<div>DESIGNED</div> <div>DRAWN</div> <div>CHECKED</div> <div>DATE</div>	RESPEC	MAB
	8 COLORADO BLVD	HJG
	SUITE 411S	MAB
	DENVER, CO 80246	
	PHONE (303) 757-3655	7/6/18
<div>STAMP</div>		
<div><div></div><div>Know what's below. Call before you dig.</div></div>		
<div>PROJ NO. 03437 DWG NM. 03437-DEV</div>		
<div>COPESTONE GENERAL CONTRACTORS 1624 S. 21ST ST COLORADO SPRINGS, CO. 80904</div>		
<div>LOT 2, APPALOOSA HWY 24 SUBDIVISION FIL 1A</div>		
<div>BUILDING ELEVATIONS AND FLOOR PLAN</div>		
<div>DRAWING NUMBER: <div>C</div><div>SHEET 4</div></div>

Markup Summary

PROJ NO. 03437 DWG NM. 03437-DEV			
COPESTONE GENERAL CONTRACTORS 1624 S. 21ST ST COLORADO SPRINGS, CO. 80904			
LOT 2, APPALOOSA HWY 24 SUBDIVISION FIL 1A			
BUILDING ELEVATIONS AND FLOOR PLAN			
DRAWING NUMBER: C SHEET 4

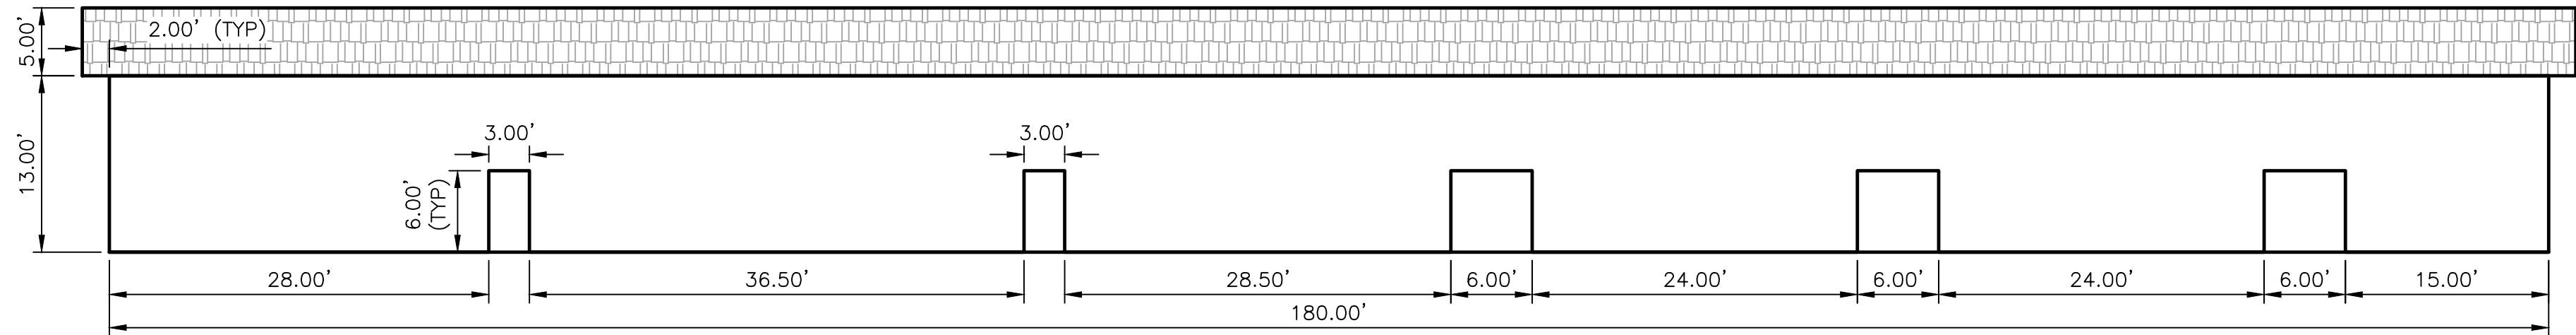
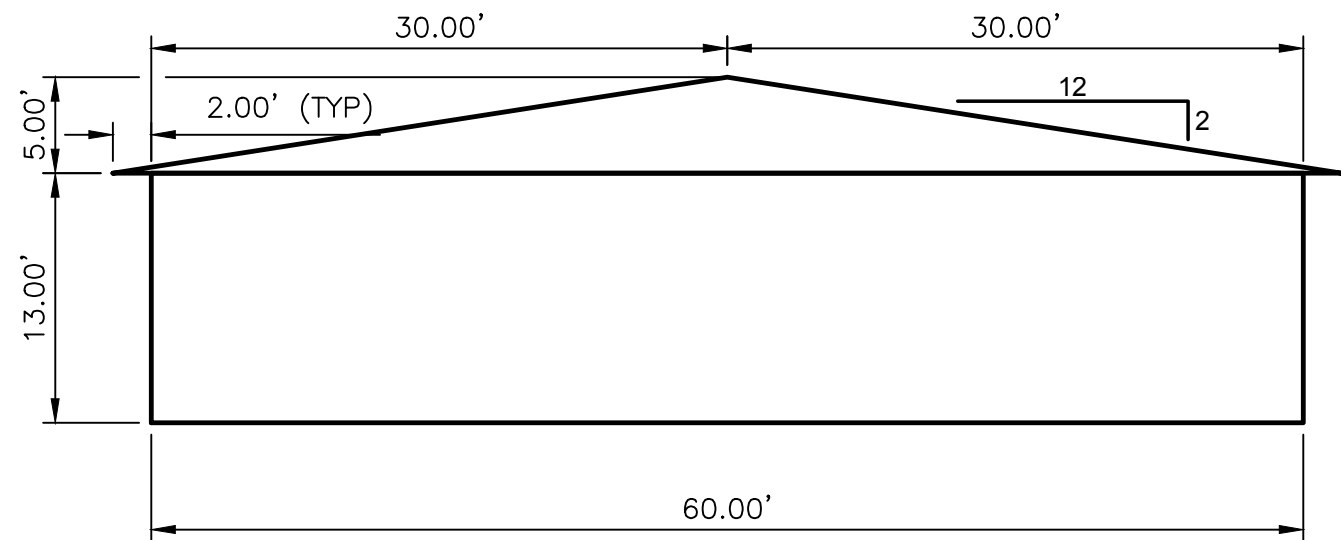
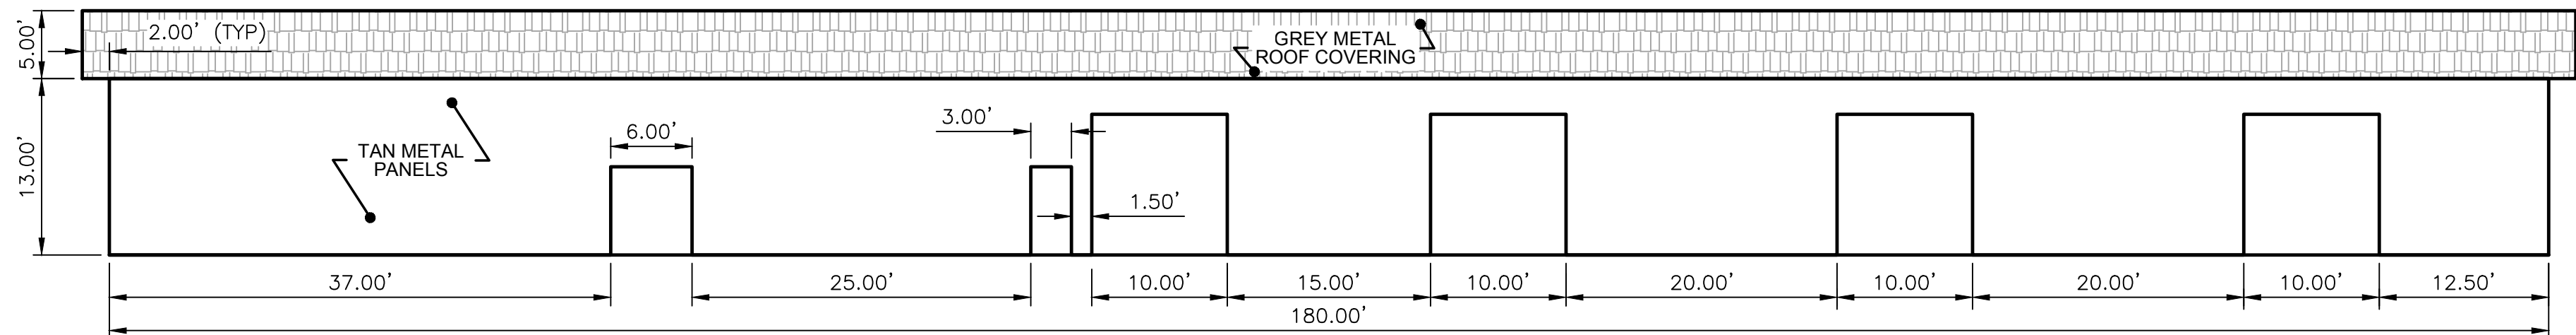
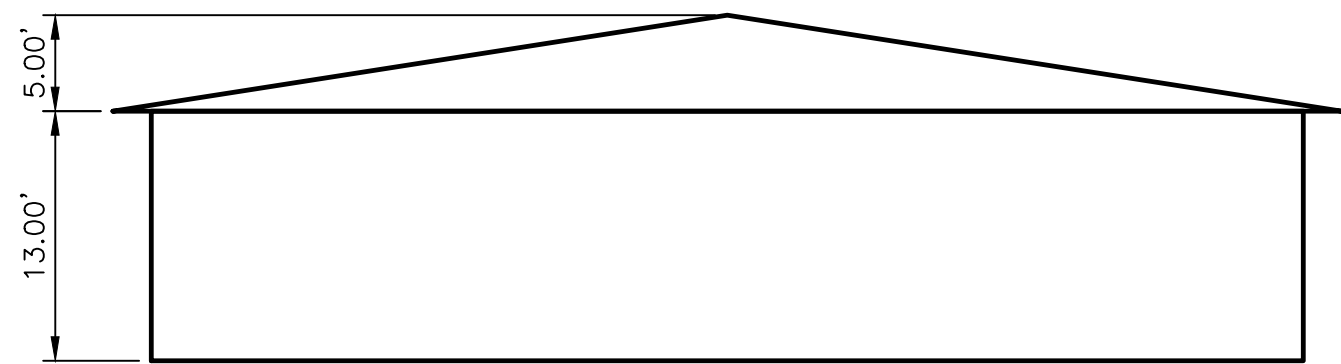
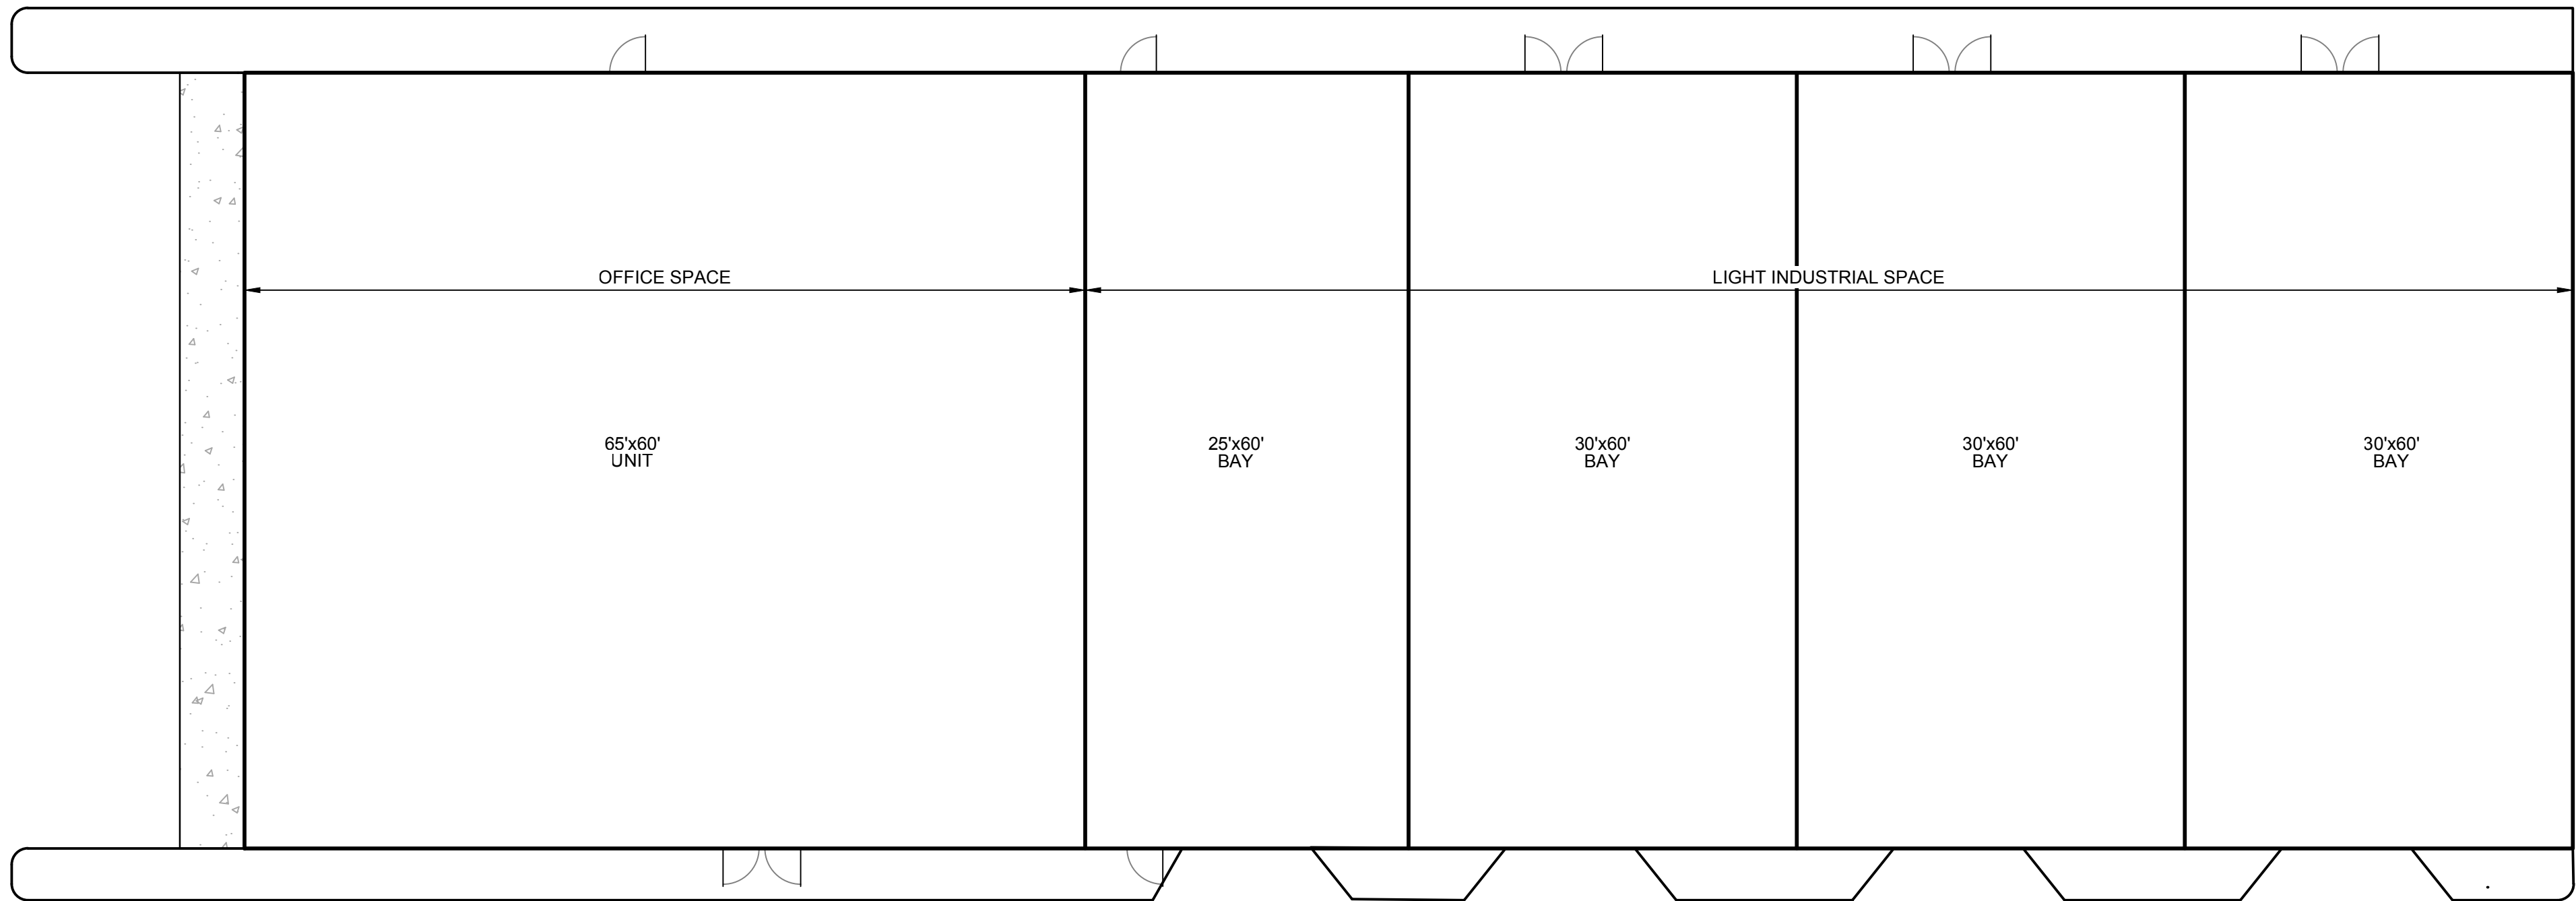
Subject: Callout
Page Label: [1] Arch Elev
Lock: Unlocked
Author: dsdkendall
Date: 2/13/2019 11:45:48 AM
Color:

Is this a warehouse?
